**Regain Spent Potlining Treatment Facility – Response to Submissions  
MP 06\_0050 Modification 2**

I refer to your email to the Environment Protection Authority (EPA), dated 2 April 2019, seeking the EPA's review of the proponent's response to submissions for the Regain Spent Potlining Treatment Facility modification application, reference MP 06\_0050 Mod 2. The proponent's response is detailed in the report titled "Response to Submissions Report" (RTS), dated 29 March 2019 and prepared by Aecom Australia Pty Ltd.

### **Additional Information Required – Regain (MP 06 0050 Mod 2)**

### **Assessment of matters adequately addressed in the Response to Submissions**

Figure 8 Maximum Incremental PAH Isopleth 99.9th Percentile

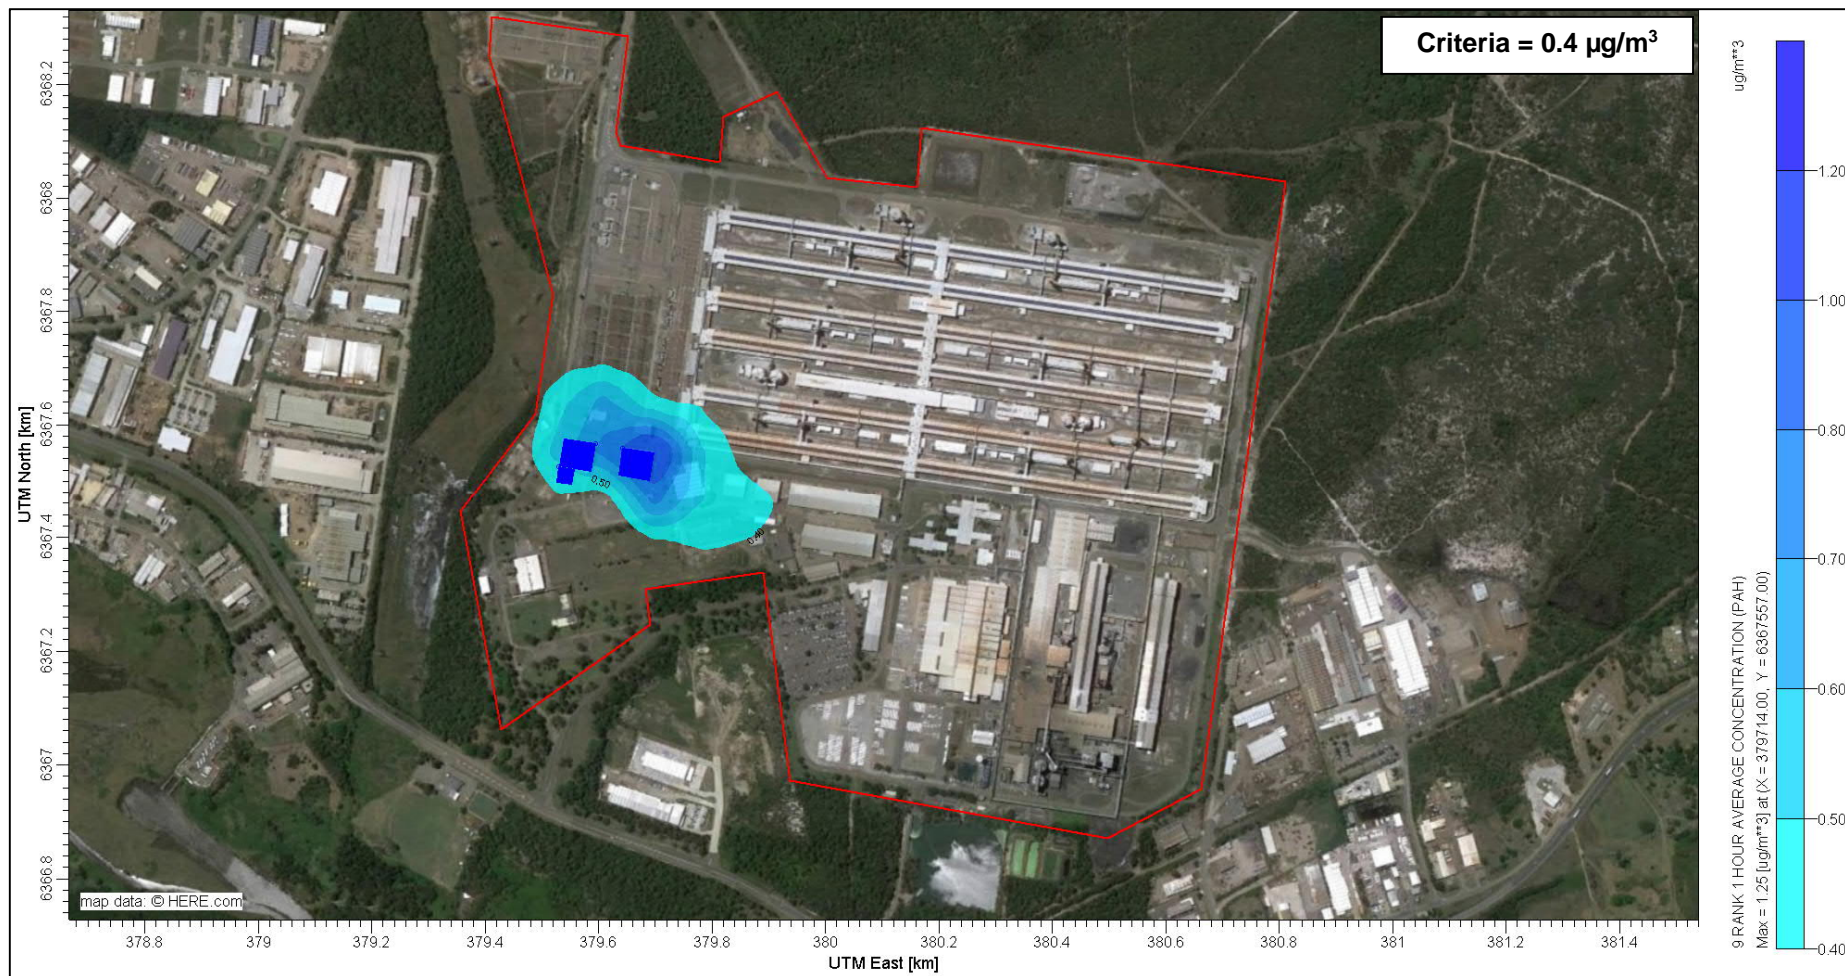
If results of the average monitoring data (scenario 1) are scaled to account for maximum monitoring data for PAHs, predicted ground level concentrations for PAHs are approximately 75% of the impact assessment criteria. Additionally, Scenario 2, based on proposed EPL limits, predicts ground level concentrations for PAHs are approximately 91 % of the impact assessment criteria.

The revised assessment does not advise on the methodology for assessing PAHs (including the specification profile of PAHs), noting that:

- Current EPL limit for PAHs is not as benzo(a)pyrene equivalent;
- The impact assessment criteria for PAHs is based on benzo(a)pyrene equivalent.

The proponent must provide further information on the assessment approach for PAHs, including the provisions of test data, PAH specification profile, and the application of potency equivalency factors for the specification PAH profile.

**Recommendation:** Proponent must provide further information on the assessment approach for PAHs including the application of potency equivalency factors, and whether PAHs have been assessed as benzo(a)pyrene equivalent.

Figure 9 Maximum Incremental Cadmium Isopleth 99.9th Percentile

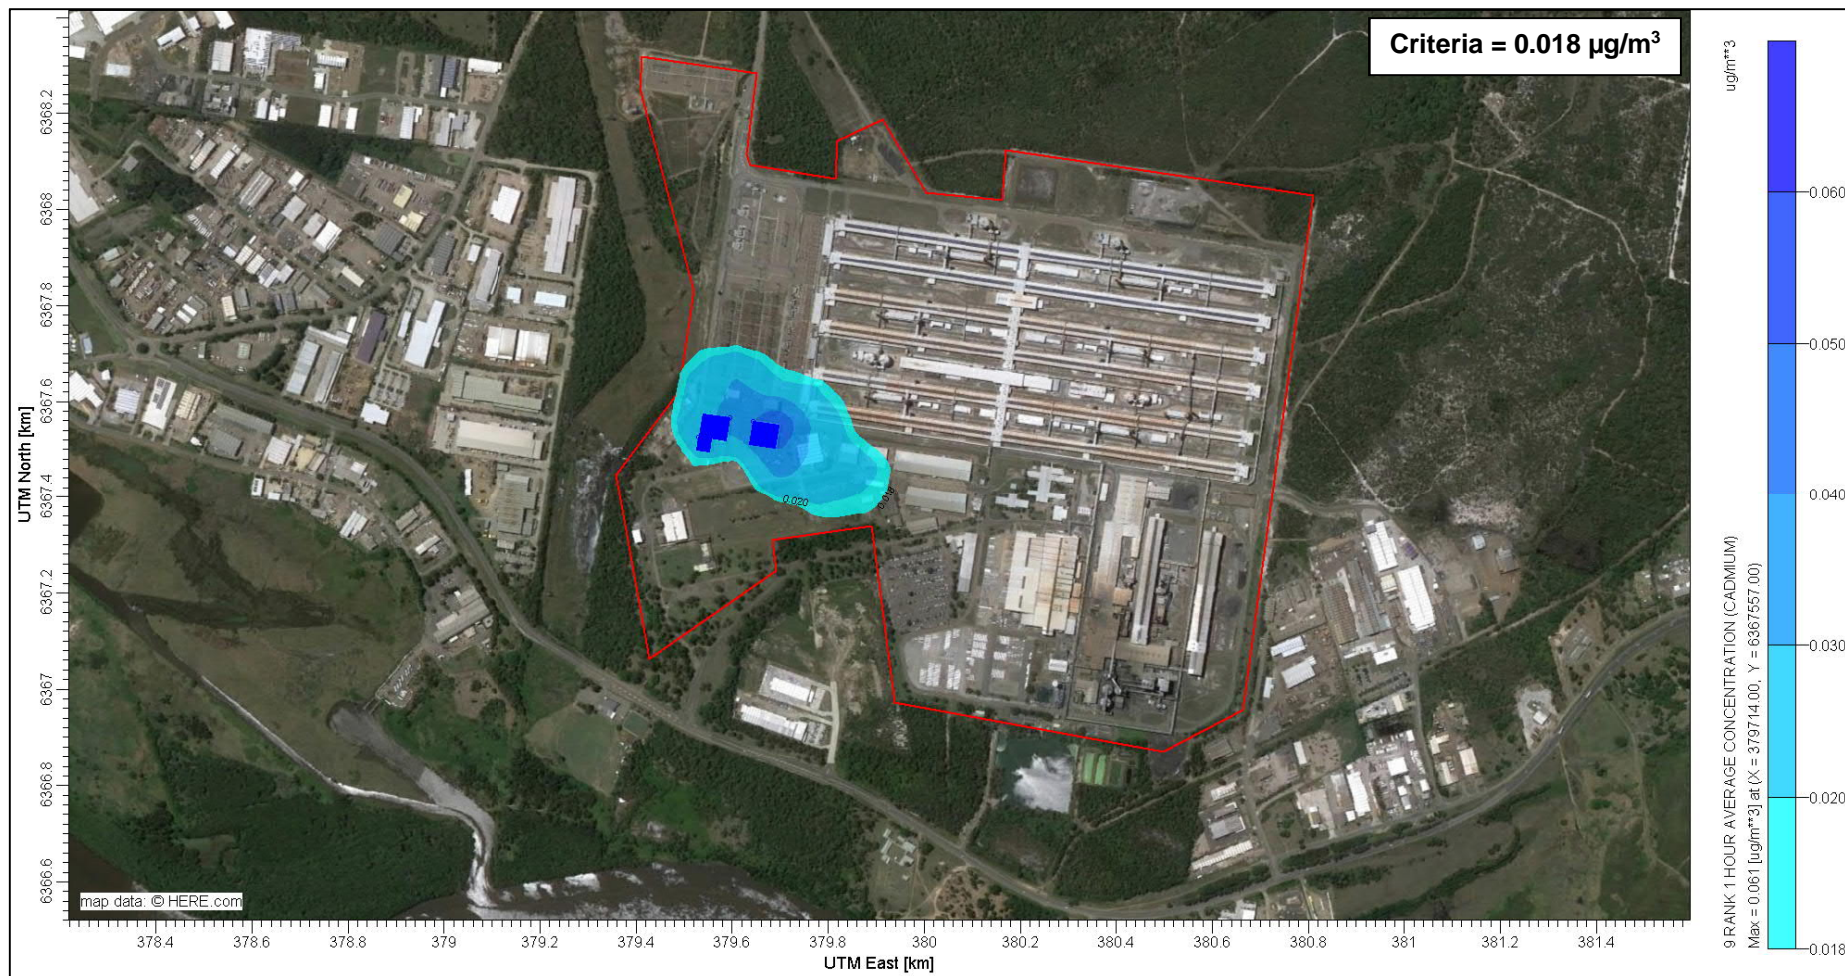
If results of the average monitoring (scenario 1) are scaled to account of maximum monitoring data, predicted ground level concentrations for cadmium are approximately 60 % of the impact assessment criteria. Additionally, Scenario 2, based on proposed EPL limits, predicts ground level concentrations for cadmium are approximately 99% of the impact assessment criteria.

Given the lack of further detailed assessment for cadmium accounting for other significant sources, the EPA recommend that limits for cadmium be included for all existing and proposed emission sources that are representative of 'no net increase' for cadmium emission intensity. Based on a current cadmium limit of 0.035 mg/m<sup>3</sup> for the existing kiln, a limit of 0.018 mg/m<sup>3</sup> for both the existing and proposed kilns discharge points is proposed.

**Recommendation:** In the absence of further assessment accounting for cadmium emissions from other significant sources, a revised cadmium limit of 0.018 mg/m<sup>3</sup> is recommended for both processing kilns.

Figure 10 Maximum Incremental 30-day (720-hour) Hydrogen Fluoride Isopleth 100th Percentile

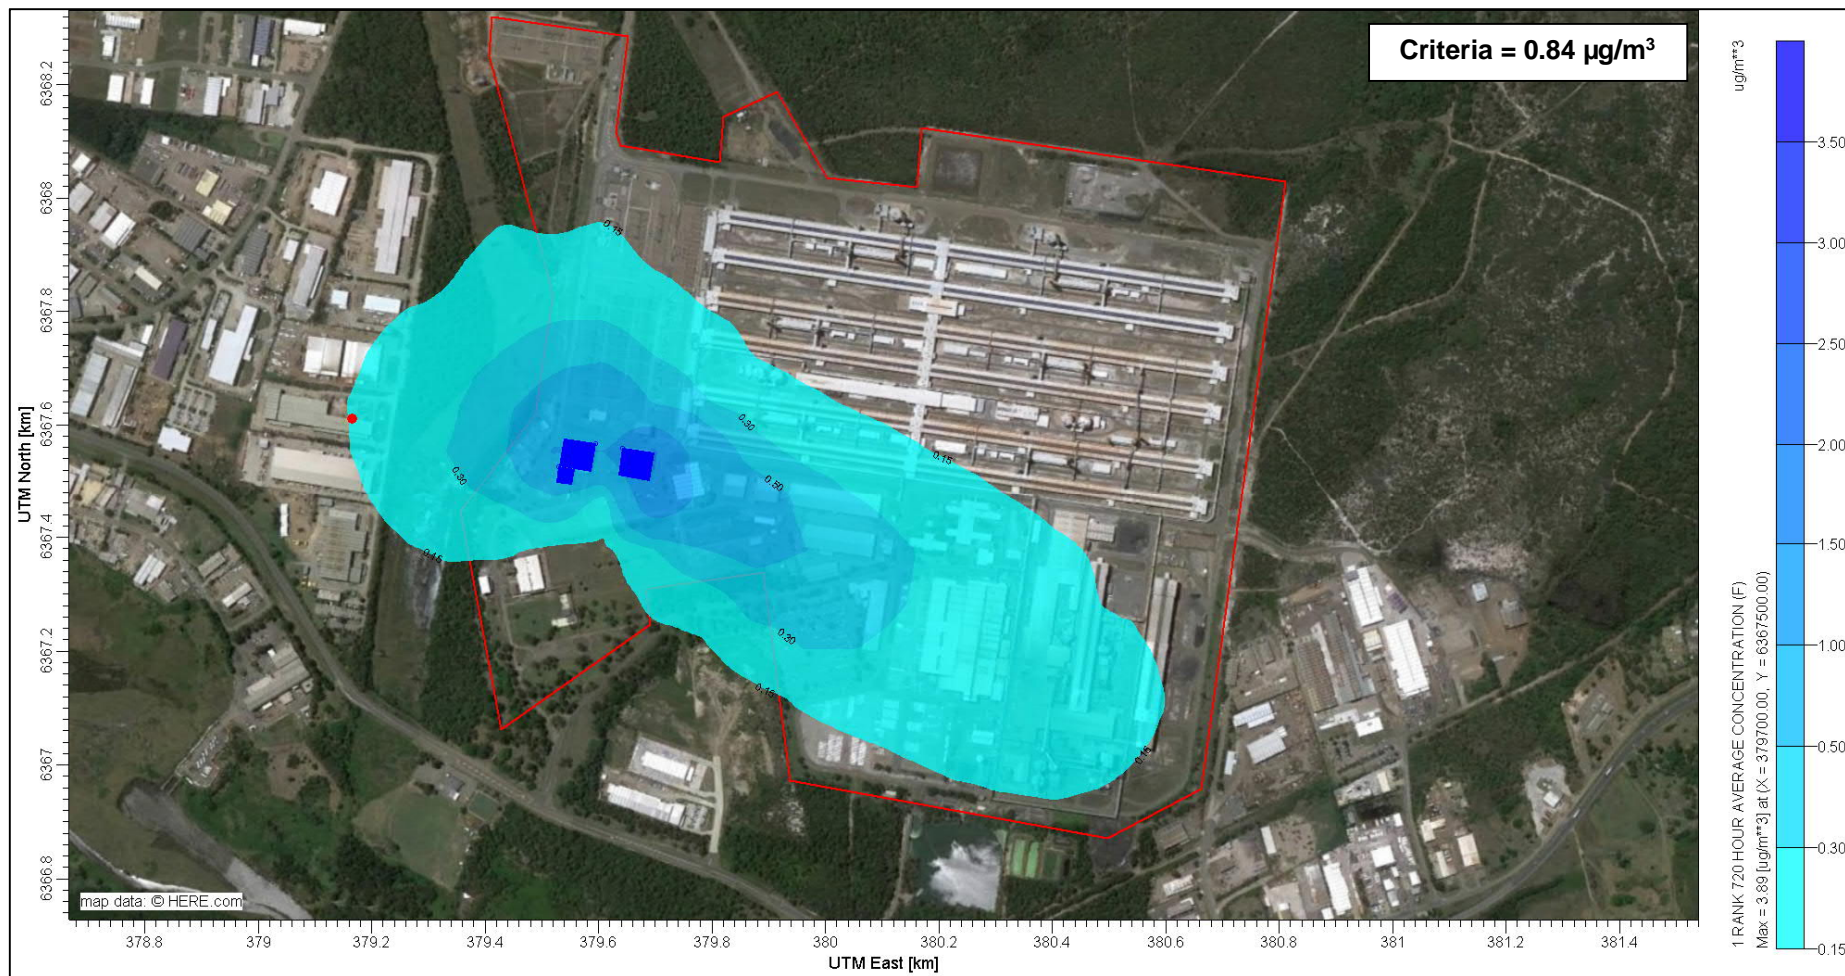
The revised assessment indicates the potential for exceedances of the impact assessment criteria for hydrogen fluoride (HF) when considering the larger range of ambient air monitoring data for hydrogen fluoride. Given the ambient air monitoring data considered for hydrogen fluoride there is potential for exceedances of the impact assessment criteria without consideration of the proposed plant and equipment. The EPA is aware that a buffer was developed for managing fluoride emissions from the Tomago facility. The ambient air monitoring data collected represents locations located within that buffer.

It is noted that the predicted incremental ground level concentrations for HF (considering maximum source monitoring data from the existing plant) are approximately 14 % of the impact assessment criteria at industrial receptors and approximately 4 % of the impact assessment criteria at residential receptors. When considering emission estimates based on proponent proposed EPL limits, the predicted incremental ground level concentration of HF is approximately 6 % of the impact assessment at residential receptors and approximately 24 % of the impact assessment criteria at industrial receptors.
